From: Gareth Ryman [REDACTED]
Sent: 10 October 2016 10:53
To: Planning.Responses
Cc: David Innes
Subject: BR/214/16/DOC - University of Chichester Upper Bognor Road Bognor Regis PO21 1HR

DRAWING TITLE
External General Arrangement Elevations -
Sheet 5

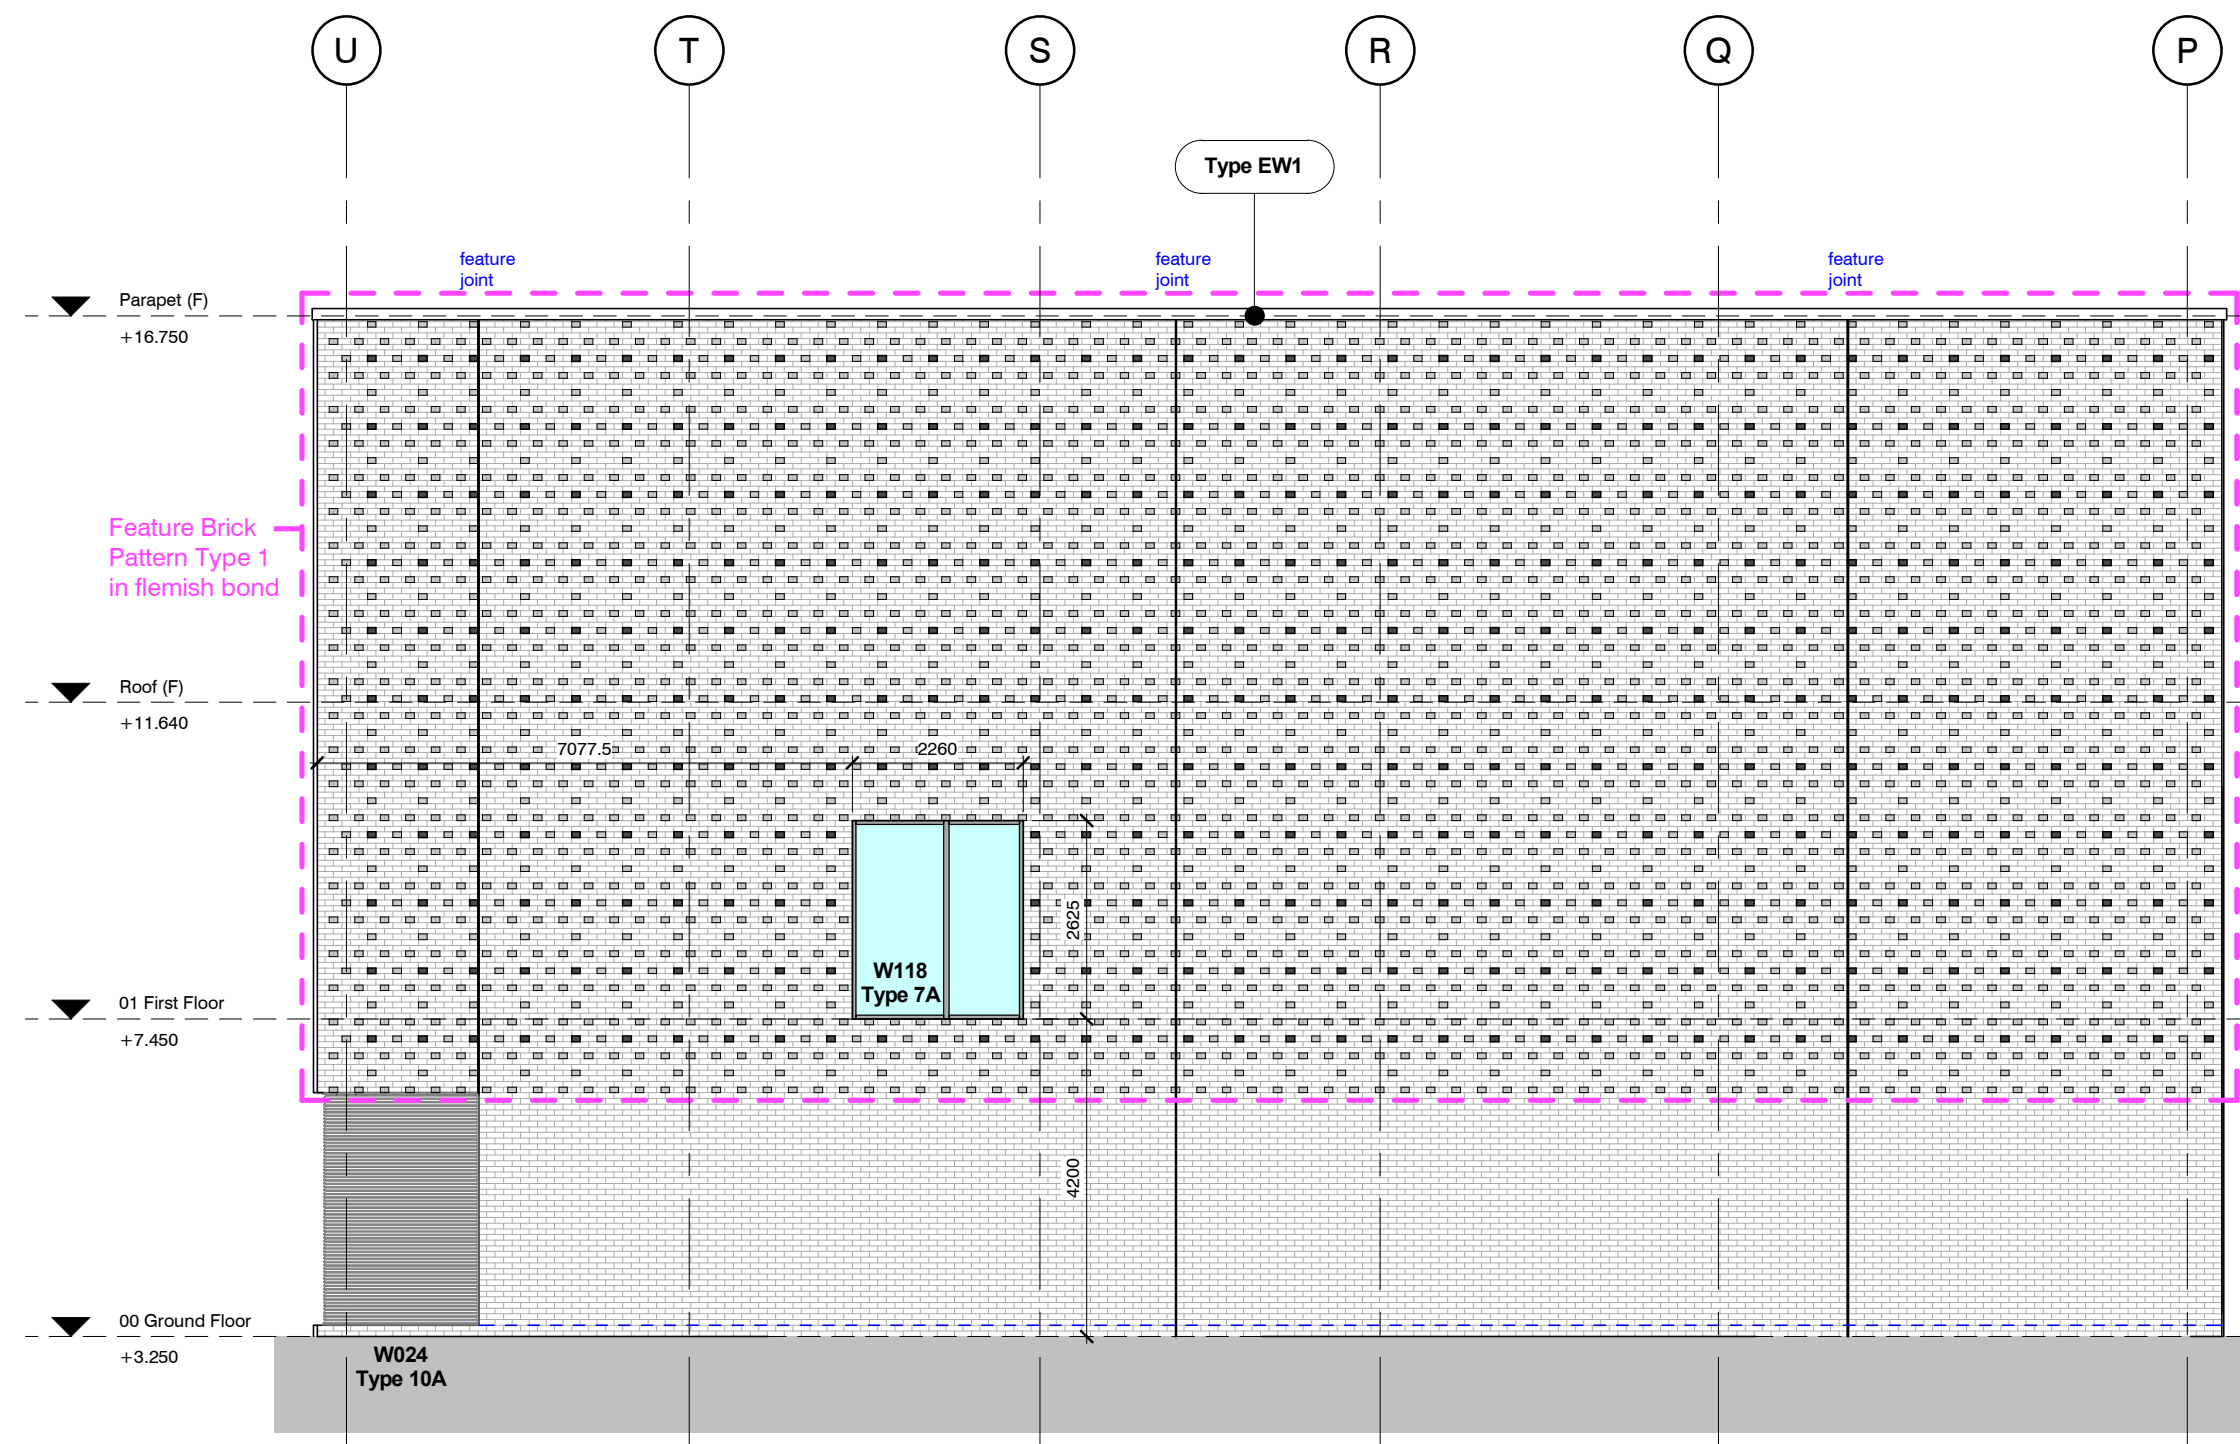
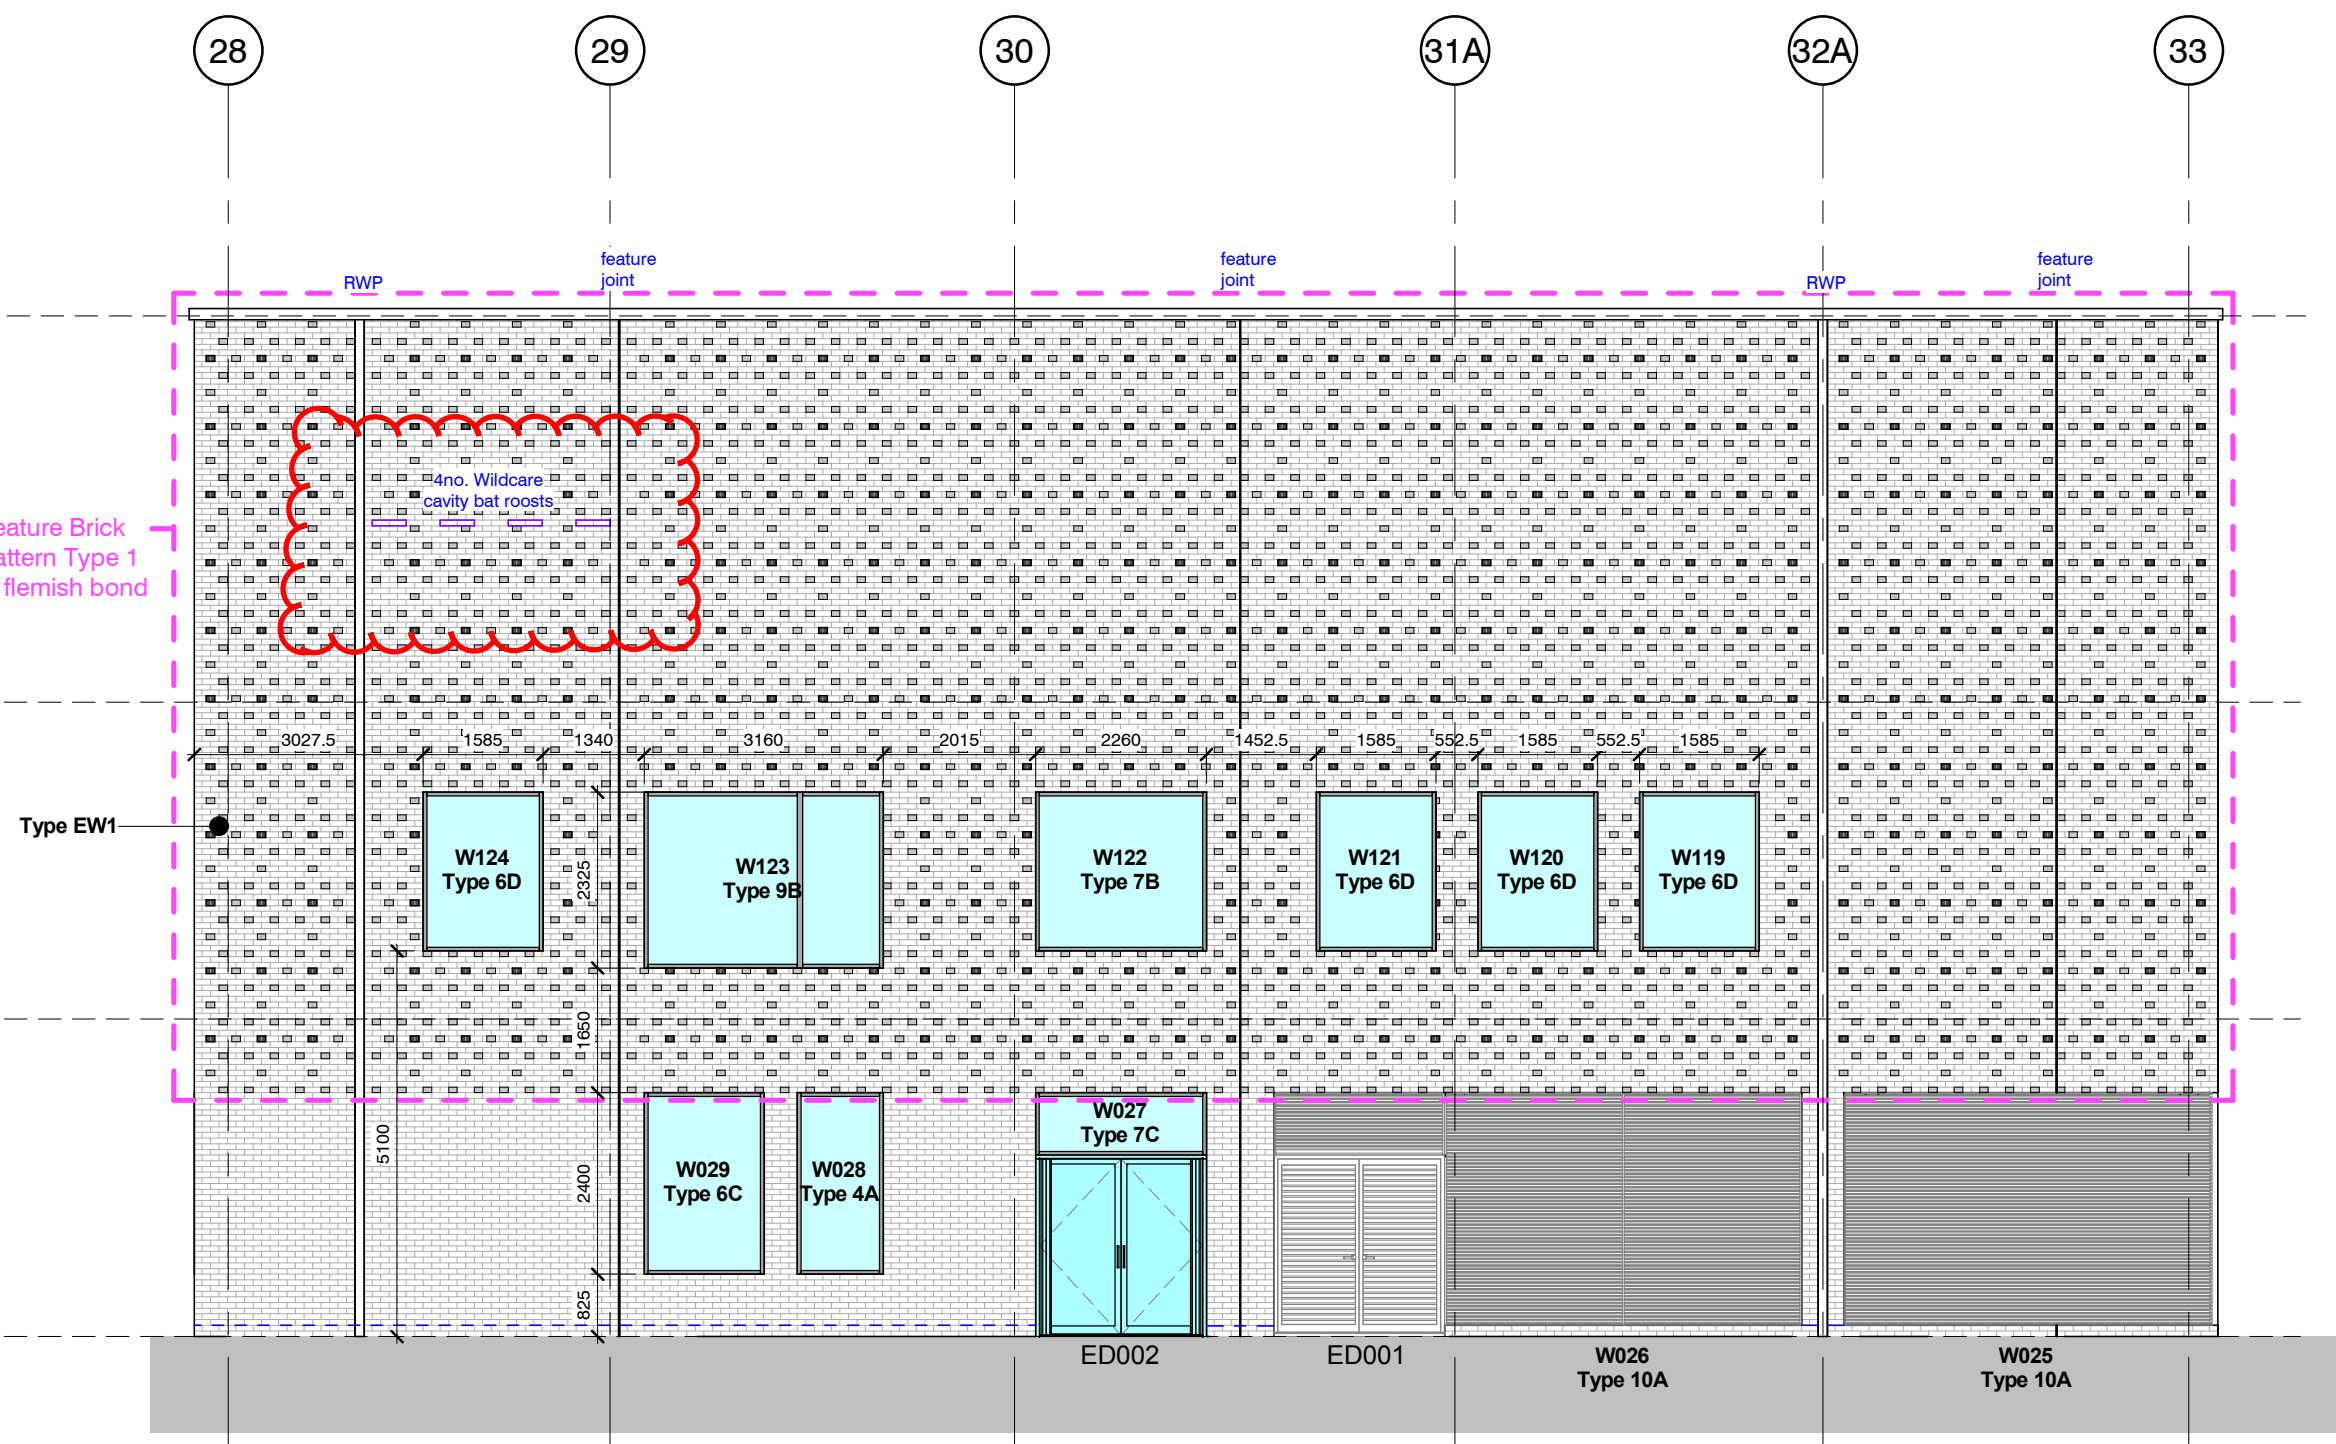
We would like to see the placement of 5 nesting opportunities for birds (species such as swallows, swifts and housemartins), to replace any potential loss of roosting/nesting provision. Along with 2 bat roosting structures being put on/around the building. Appropriate designs can be found in the publication "Designing for Biodiversity: A technical guide for new and existing buildings". Ecological advice should be sort in when deciding where and which of these structures should be placed for maximum effectiveness, because thermal tolerances of each species are very important. Lighting will need to be kept to a minimum, as lighting levels have a effects on nocturnal species such as bats, flying invertebrates and various mammal species. To this effect we would wish to see a lighting plan for conditioning. There will need to be a plant scheme, containing native plants only submitted for conditioning. We ask that applicants/consultants please share their survey results with [Sussex biodiversity records centre](#). If possible reed bed/fen bed soakaways should be used on site to provide drainage and additional wildlife habitat.
